From: Amanda Scholes on behalf of Planning.Responses
Sent: 24 April 2019 10:33
To: Planning Scanning
Subject: FW: LU/24/19/DOC: Windroos, Littlehampton

From: Andrew Wood
Sent: 24 April 2019 10:15
To: Planning.Responses
Subject: LU/24/19/DOC: Windroos, Littlehampton

From: Laura Gibbons
Sent: 23 April 2019 13:24
To: 'Adam Shephard'
Cc: Christian O'Brien; Rob Wilson; James Bragg; David Innes; Andrew Wood; Chris Harrison
Subject: RE: Windroos, Littlehampton

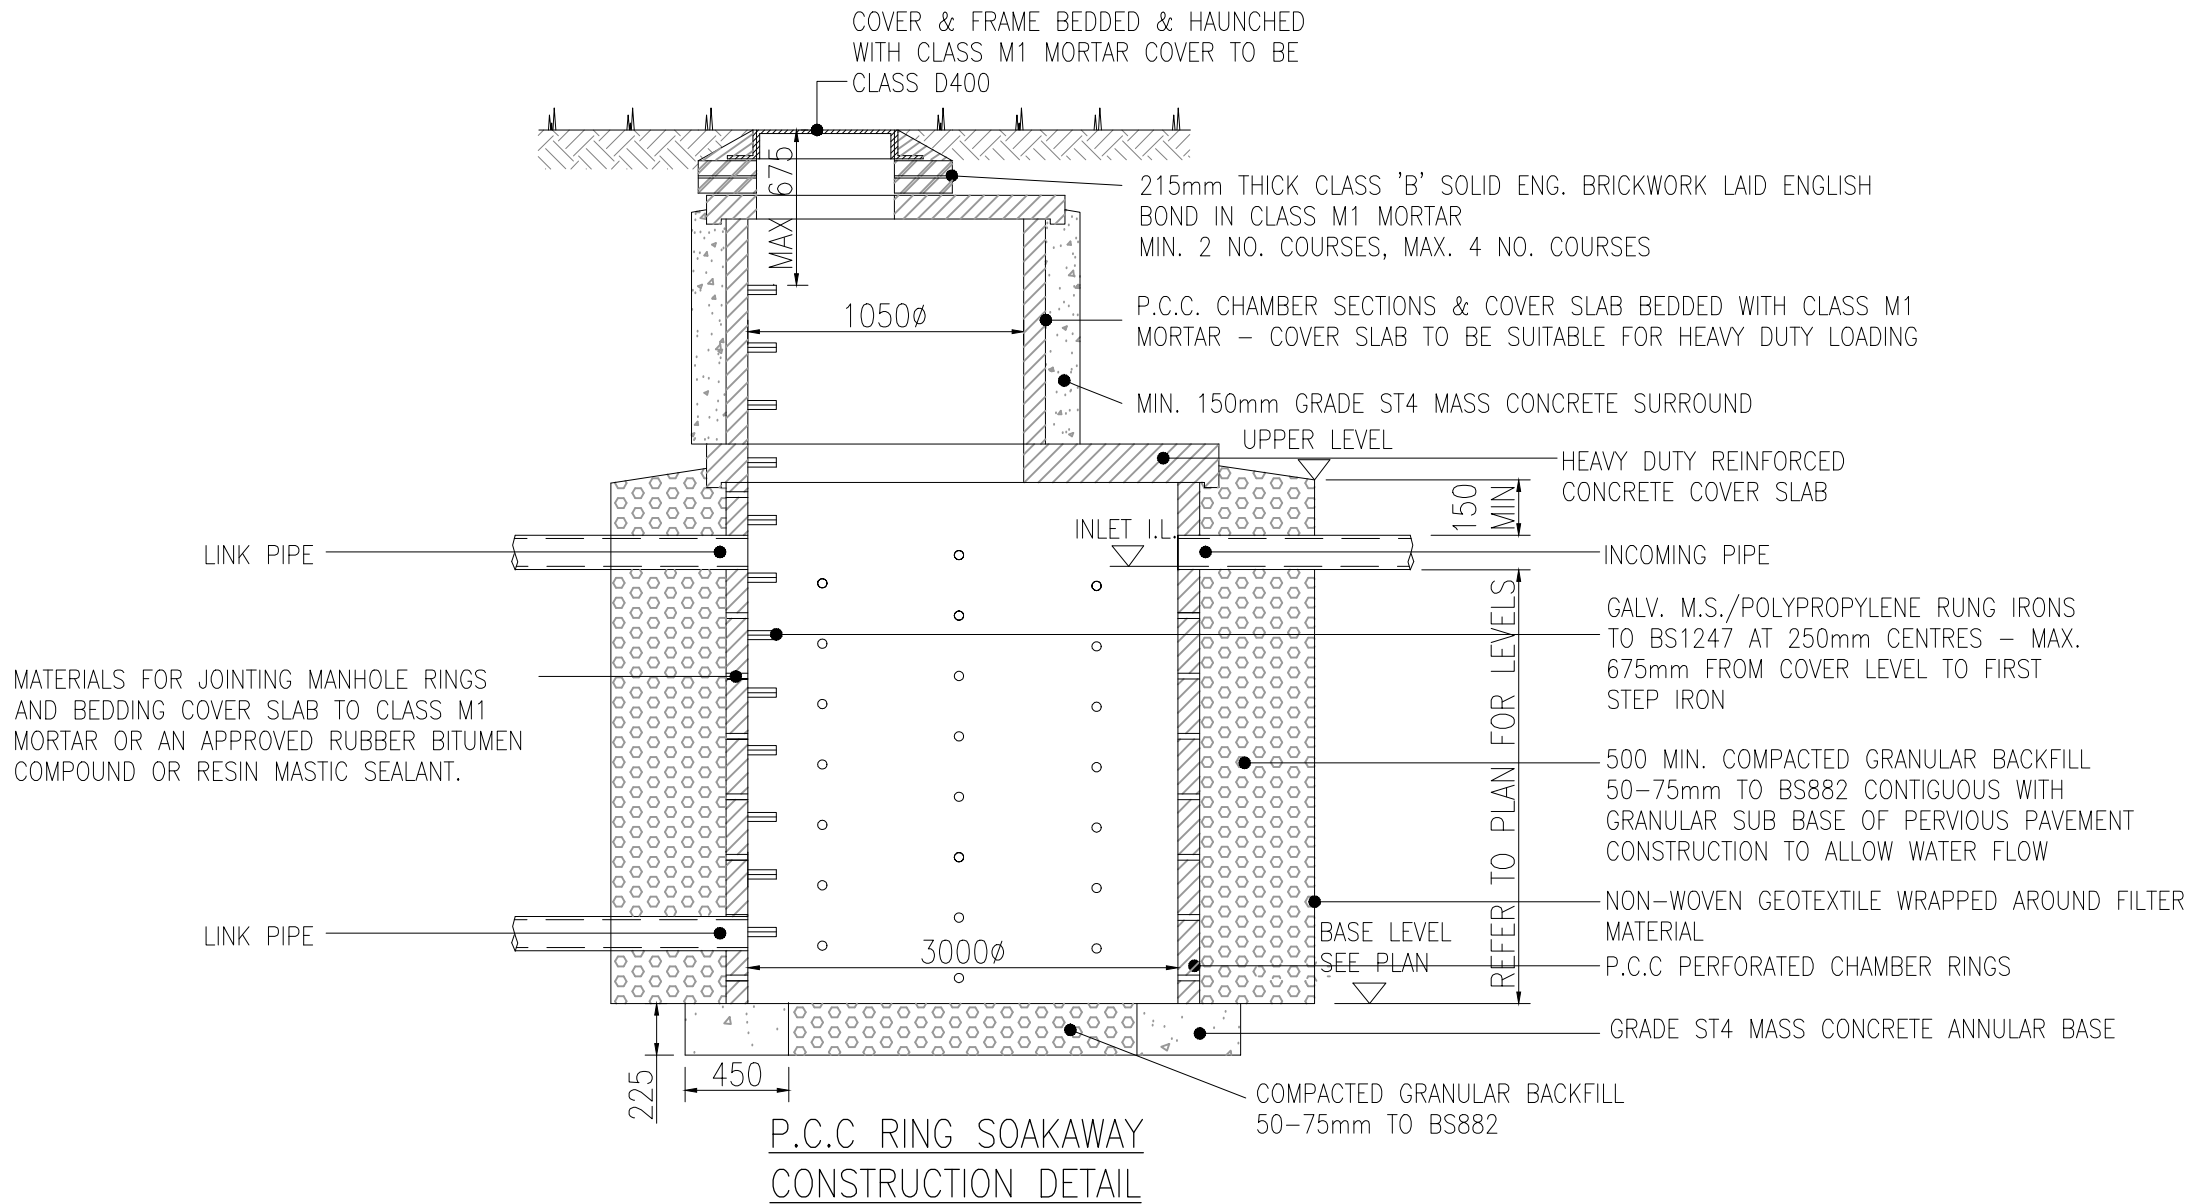
4. Catchment areas provided as attached drawings 147.5001.402 and 403. Catchments and destination infiltration structures are colour coded. Catchment areas are also provided that have been used for the calculations. The catchment area for SA08 isn't provided on the plan. I am currently experiencing problems with our plotters so haven't as yet managed to review catchment areas fully, I hope to do this later today or tomorrow (IT dependant).
